SPR EA1N and EA2 PROJECTS

DEADLINE 9 – COMMENTS ON DRAFT DCOS SUBMITTED AT DEADLINE 8

Interested Party: SASES **PINS Refs:** 20024106 & 20024110

Date: 15 April 2021 **Issue:** 1

**Figure: 29.37f**  
**Viewpoint 5: Public Right of Way, near Moor Farm**

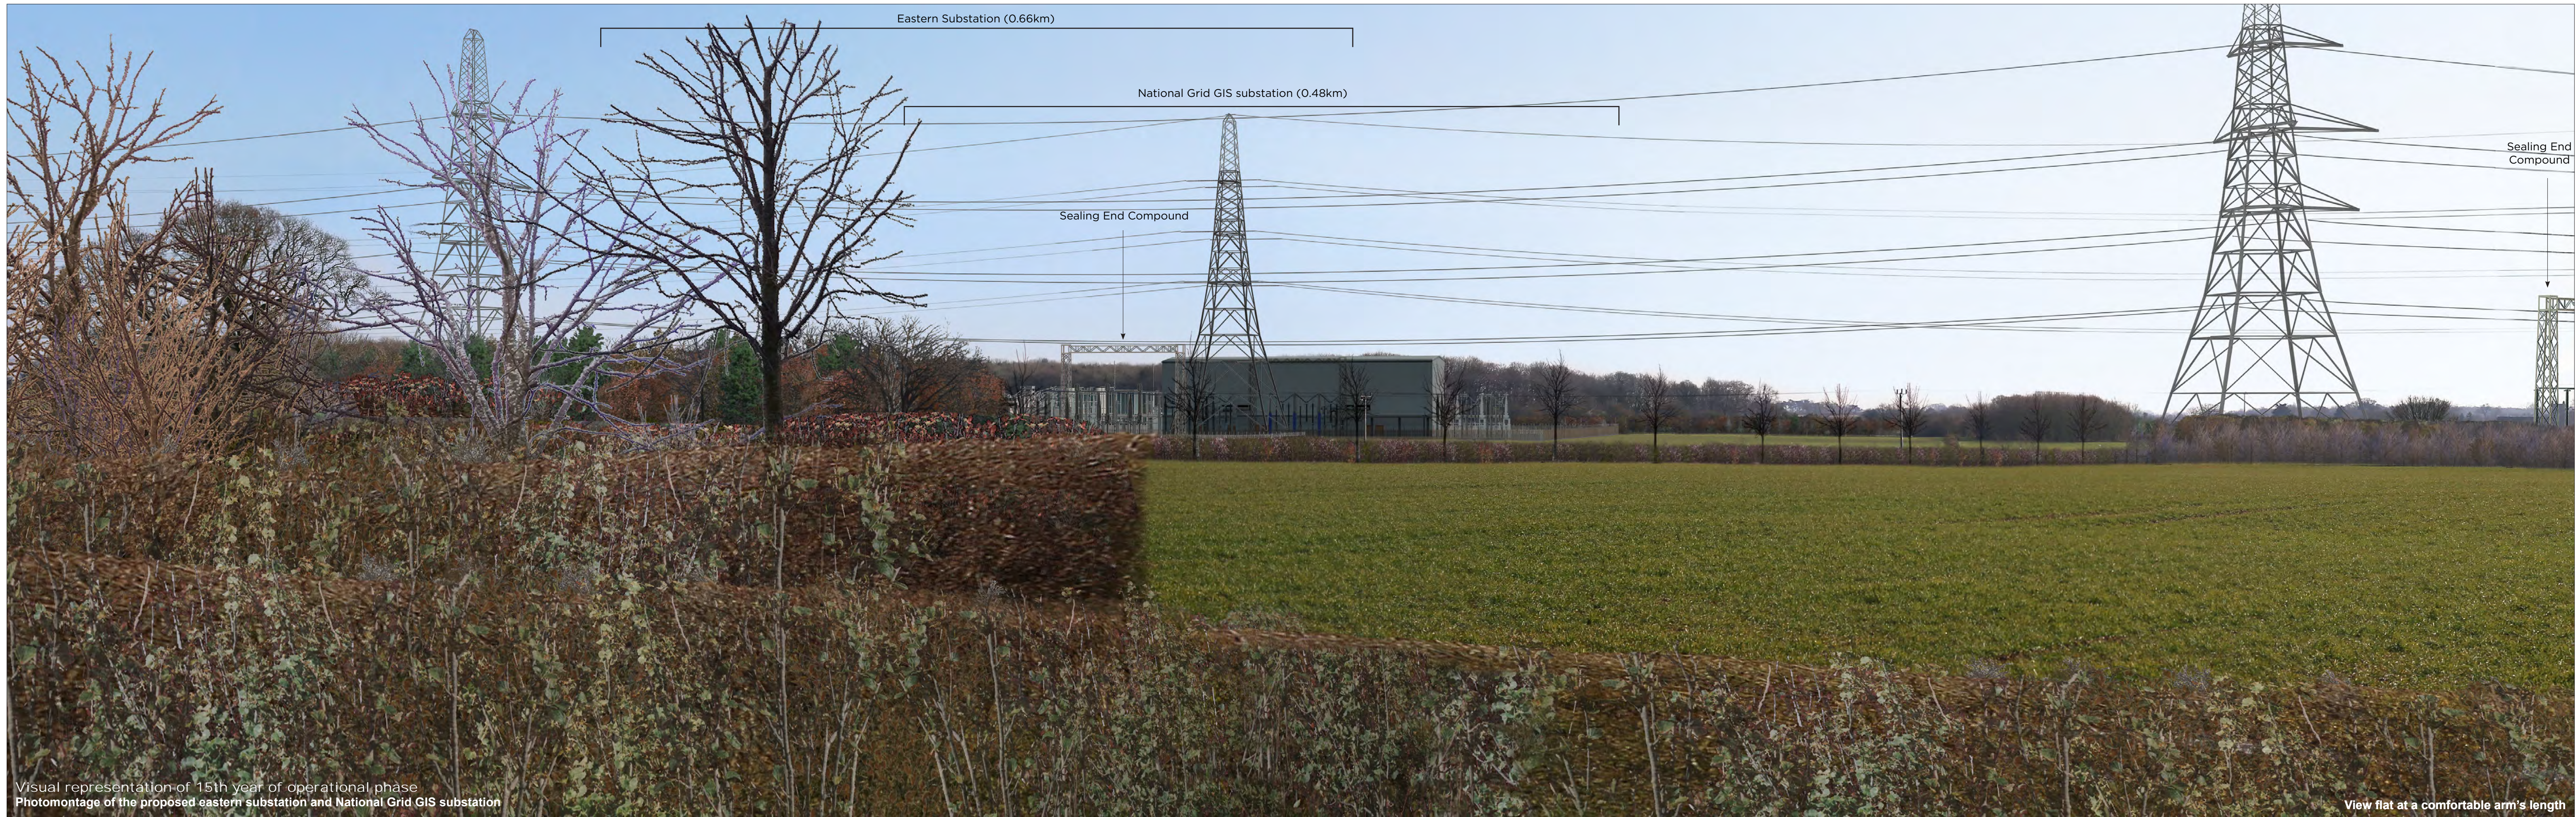
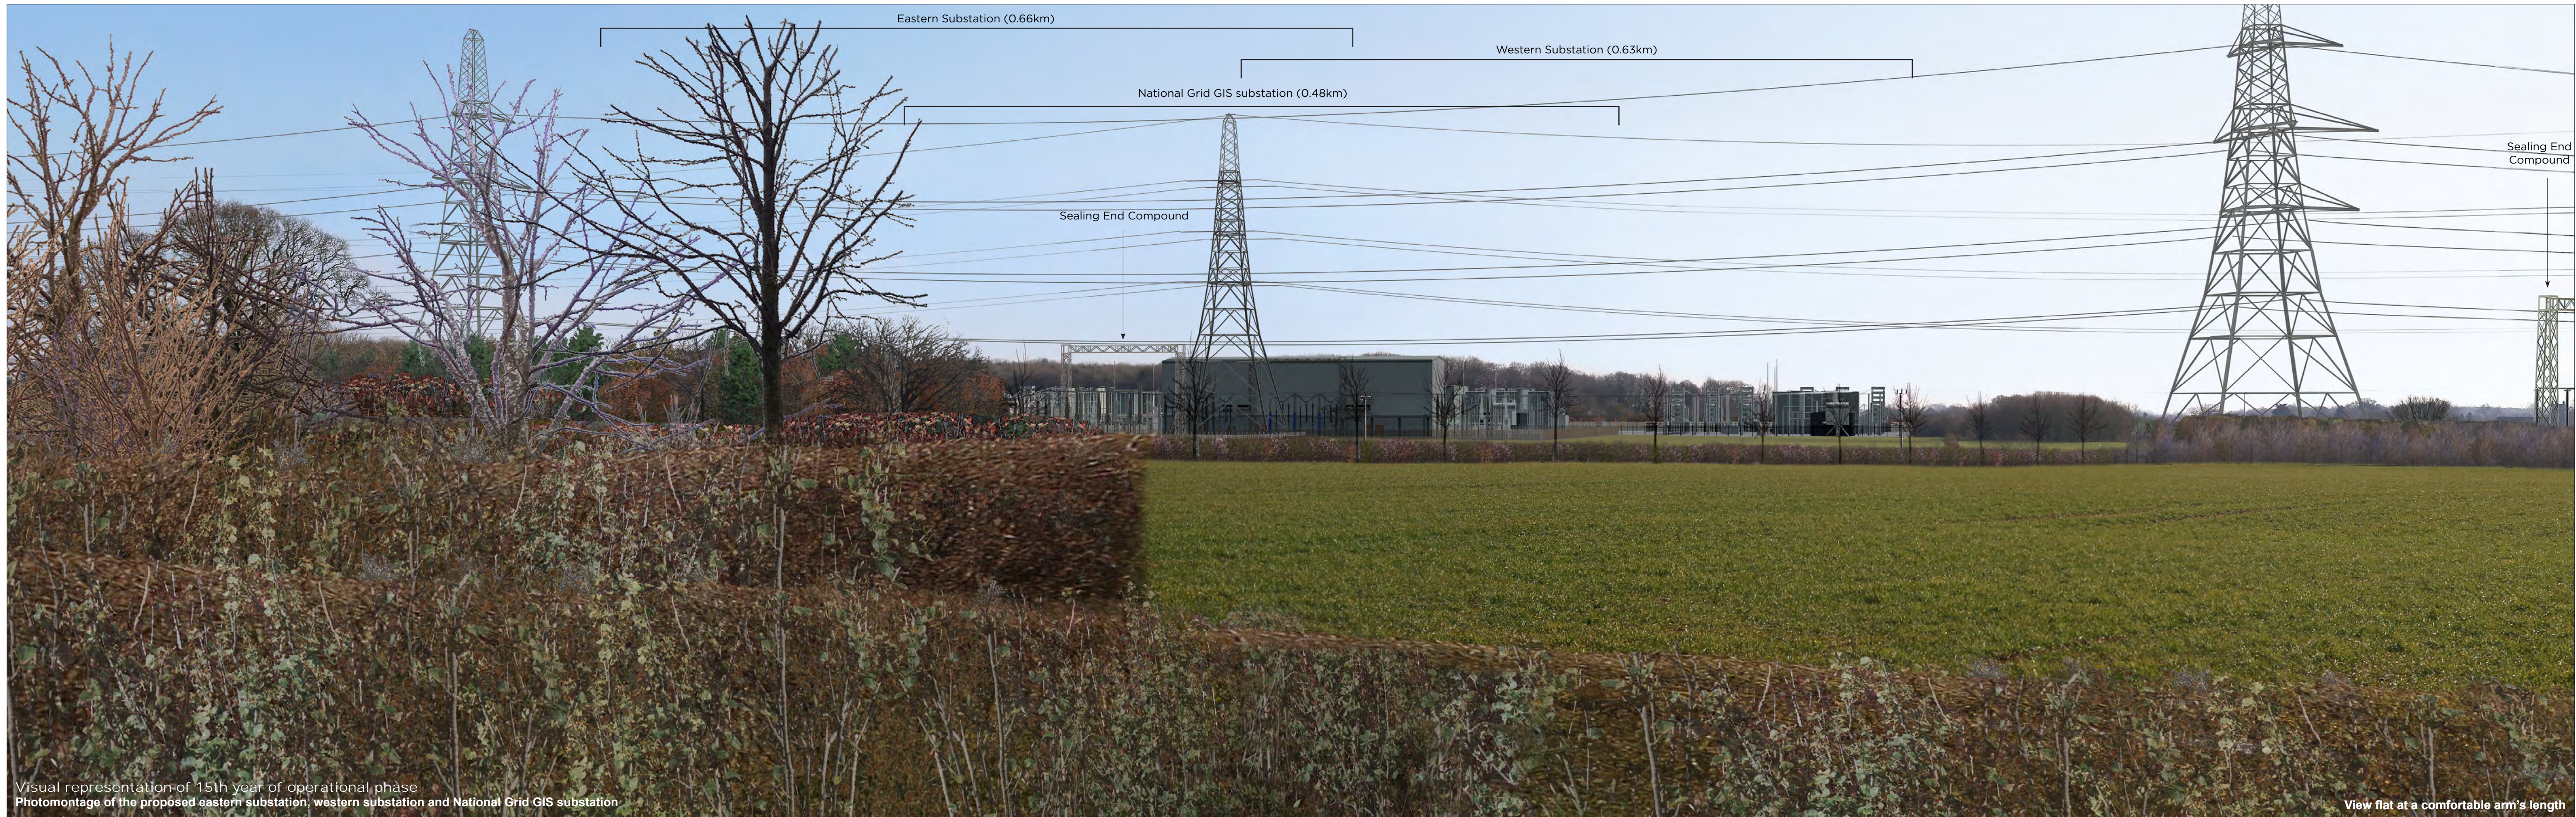
4. In respect of Schedule 1 Part 3, Requirements, SASES comments set out in paragraph 3e. remain unaddressed subject to the following comments.
 - a. Whilst the Applicants have clarified in respect of the cable sealing ends that, aside from the gantries, the electrical equipment will not exceed the height of 14.5m, it would be helpful if it could be confirmed that these are the heights used in the photomontages.
